**ANGEL PLACE
LEVEL 8, 123 PITT STREET
SYDNEY NSW 2000**

28 April 2022

SSD-10436: HORSLEY LOGISTICS PARK MOD 4 | RESPONSE TO DRAFT CONDITIONS

DRAFT INSTRUMENT OF MODIFICATION

DRAWING TITLE
ESTATE MASTERPLAN

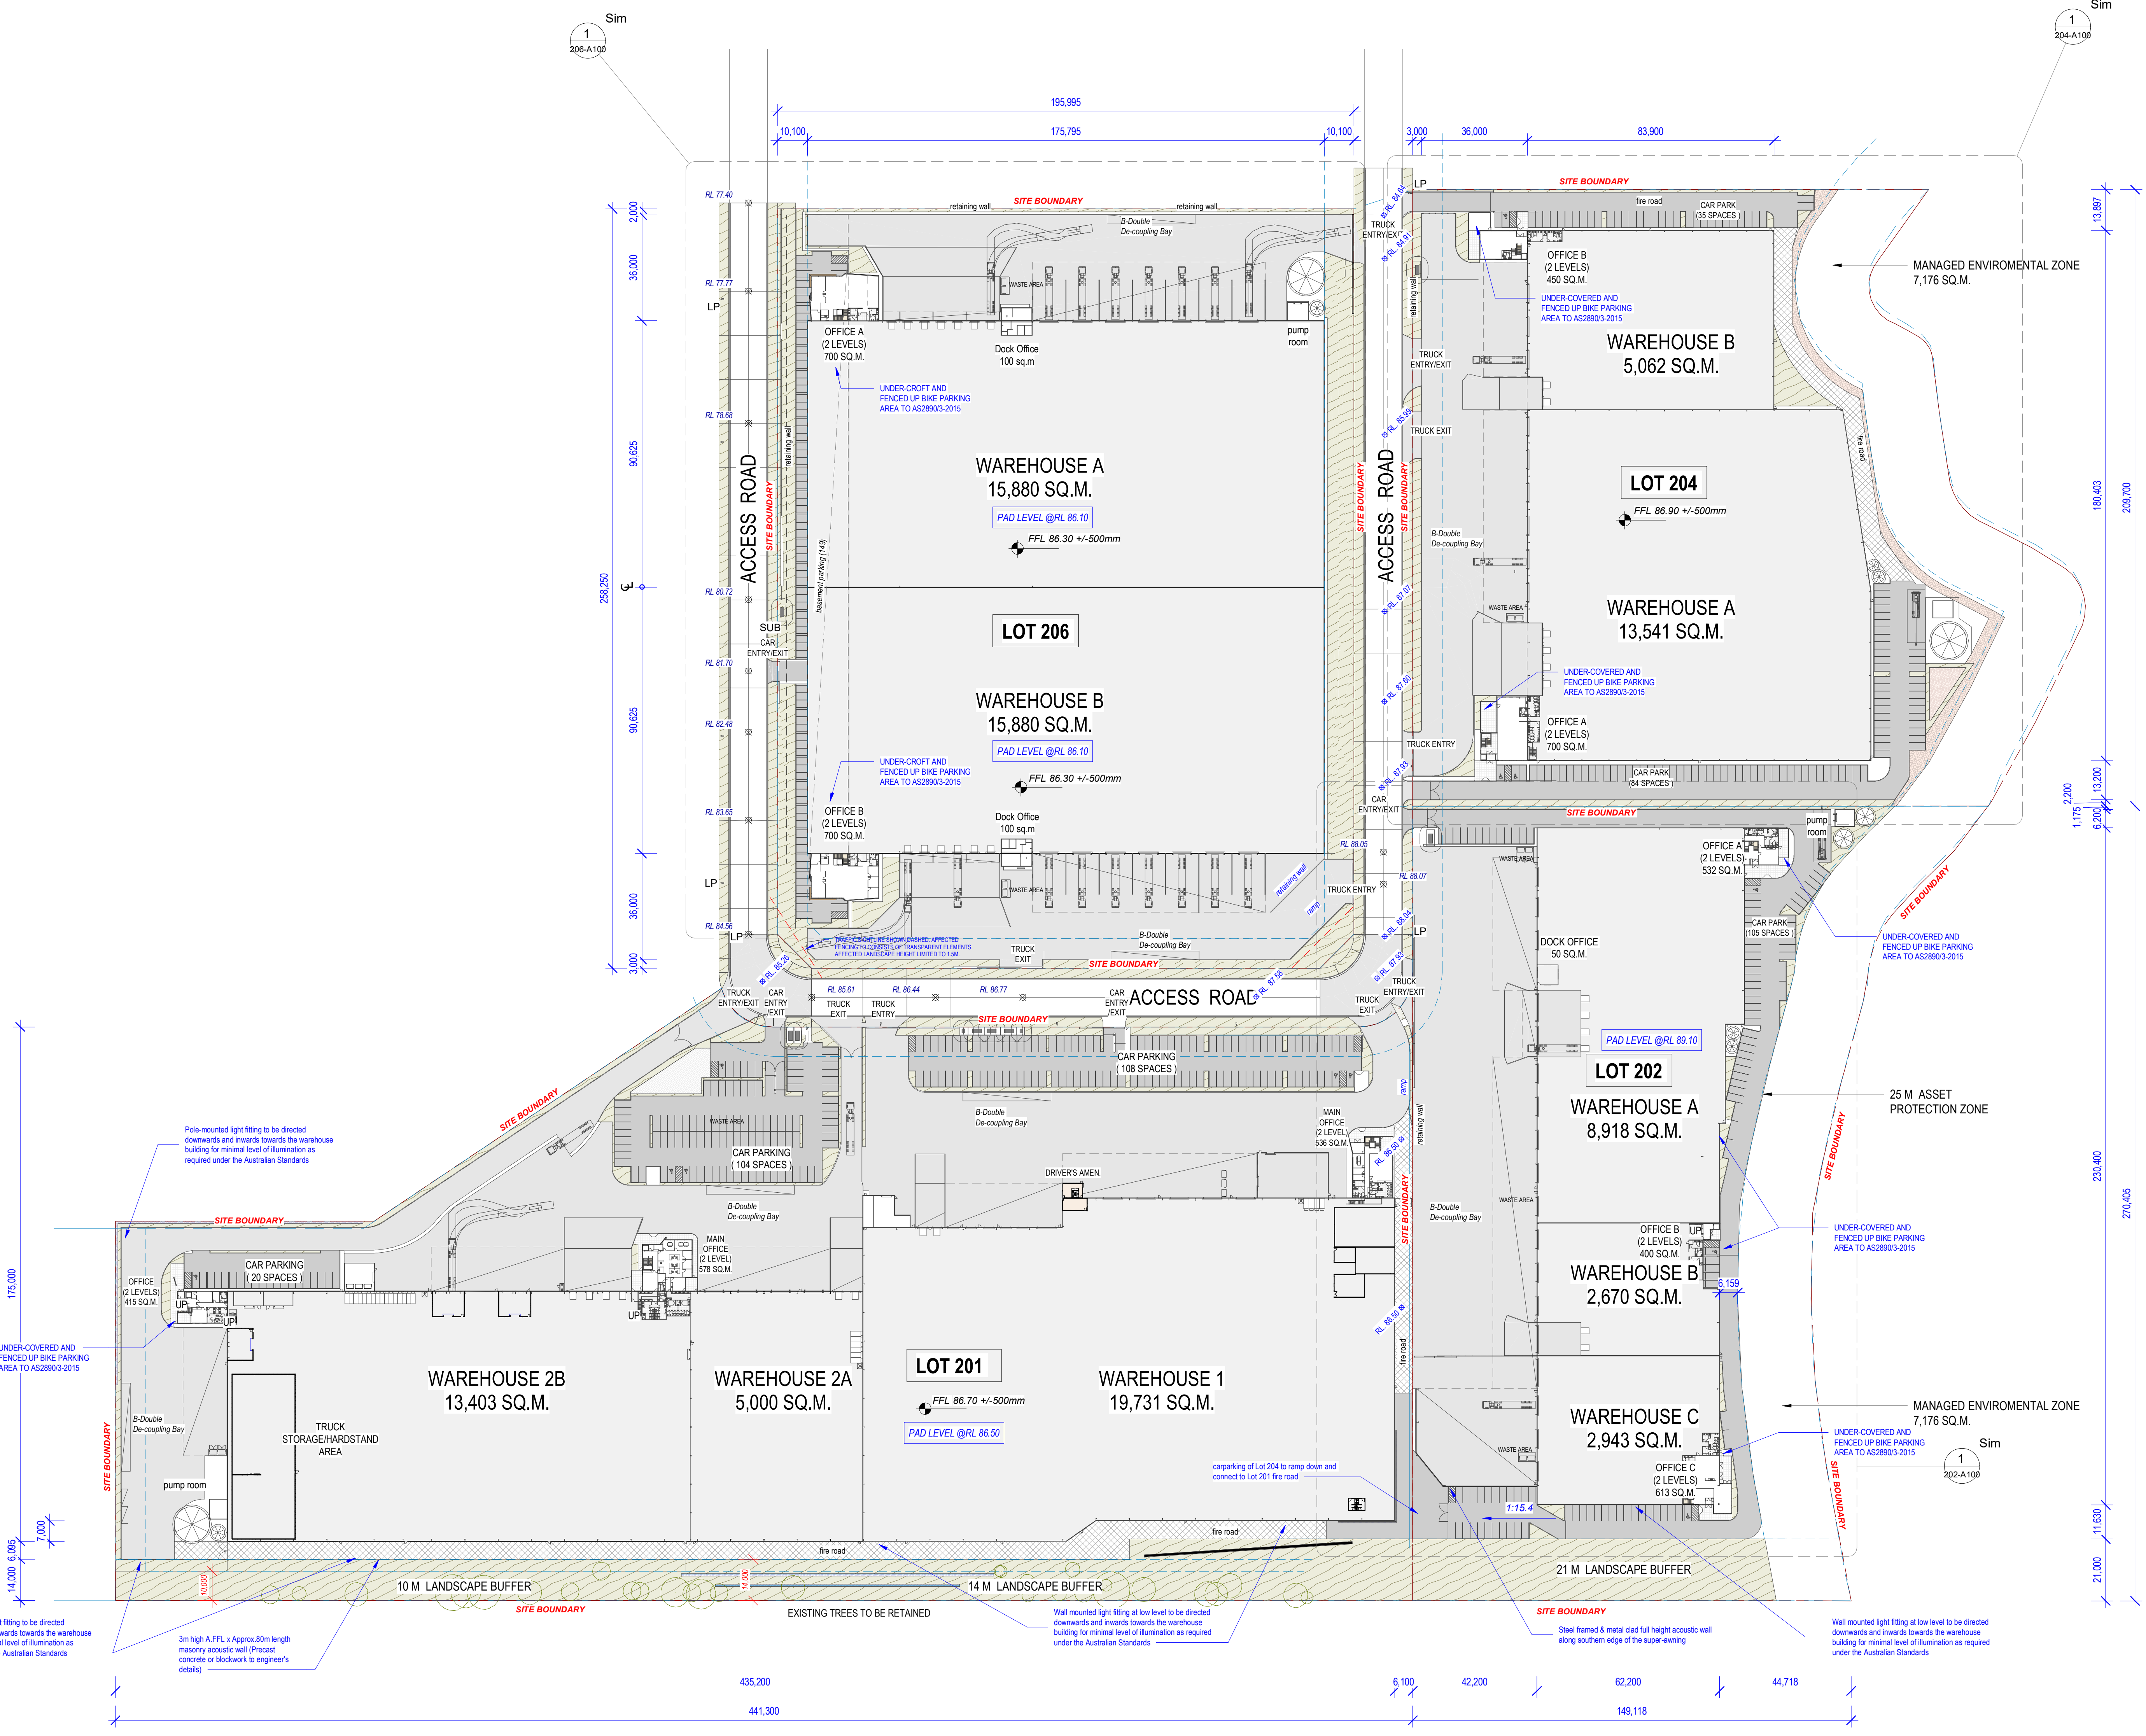
Of particular note is the sites overall GFA which the DPE have noted is to be modified as 108,962m², however ESR and Urbis believe this should be 109,515m². ESR and Urbis note this inconsistency is due to the fact that the switch and compressor room, as well as storage areas have not been calculated in the overall GFA, only the office and warehouse GFA have. The recalculated 109,515m² is inclusive of the switch and compressor room, and the storage area in Lot 201 Tenancy 1 being calculated as warehouse, and the drivers amenity area (a dock office) being calculated as office space.

We do note that the overall site area on the estate masterplan is 109,815m², this is due to the general waste area and plant room in Lot 201 Warehouse 2 not being calculated as warehouse or office space (an additional 300m² of building area). ESR and Urbis would be happy for this to be included as a line item within Schedule 2 Part A, Table 1 for consistency. However should the DPE wish to leave this off as it does not meet the definition of a warehouse or office area this would also be acceptable.

ESR and Urbis request that the DPE update these sections to capture all GFA to ensure that the stamped plans are consistent with the consent. We note that further explanation of these inconsistencies has been provided in the revised *ESR Horsley Logistics Park – SSD-10436 Mod 4* report dated 6 April 2022 and prepared by Urbis, which was submitted to the DPE on the 7 April 2022.
